OXFORDSHIRE COUNTY COUNCIL'S RESPONSE TO CONSULTATION ON THE FOLLOWING DEVELOPMENT PROPOSAL

Application no: 21/03343/F

Proposal: Variation of condition 2 (plans) of 19/01740/HYBRID - reword condition to reflect the updated revisions to drawings as well as the inclusion of new ones

Location: Land Adj To Promised Land Farm, Wendlebury Road, Chesterton

PLANNING David Lloyd CLUBS. CLIENT: CATALYST BICESTER. PROJECT: PROPOSED SURFACING & LANDSCAPE PLAN. DRAWING: TH, DATE: SEPT 2021. SCALE: 1:250 @ A1.

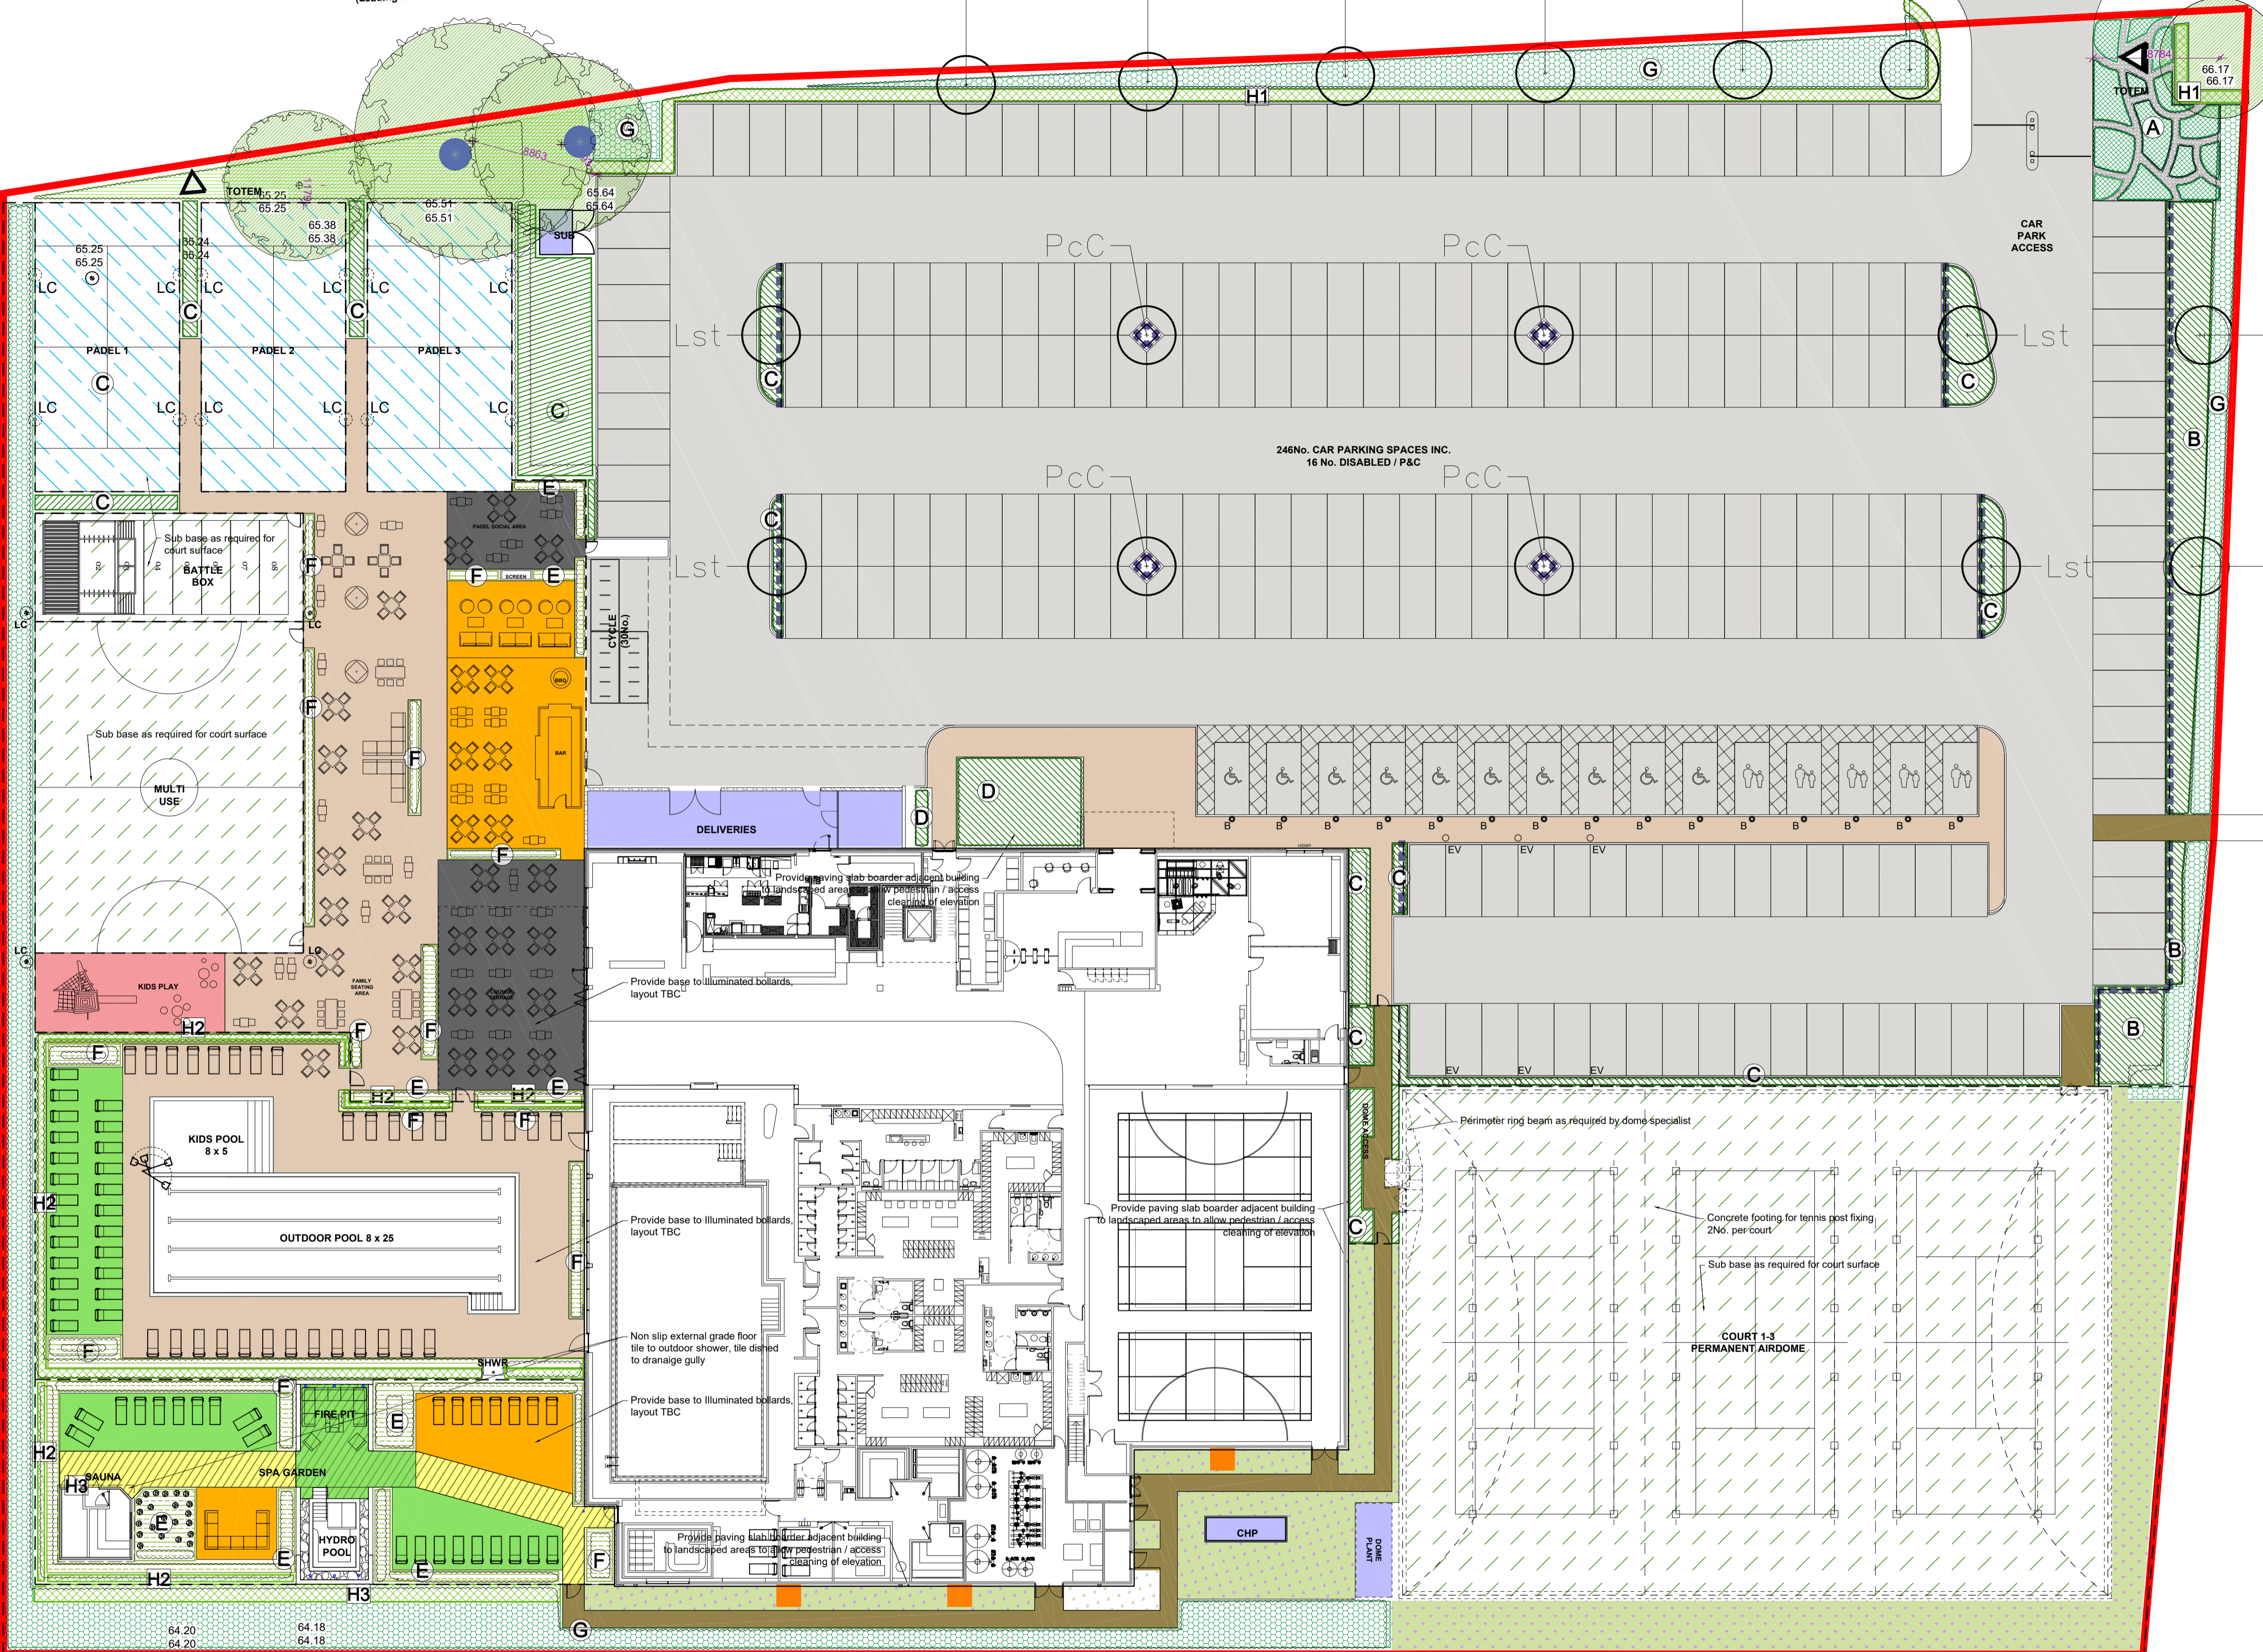
Evidence must be shown that the amendments do not cause flood risk.

Where additional padel area is proposed, this could lead to an increase in run off, hence causing a flood risk in the future.
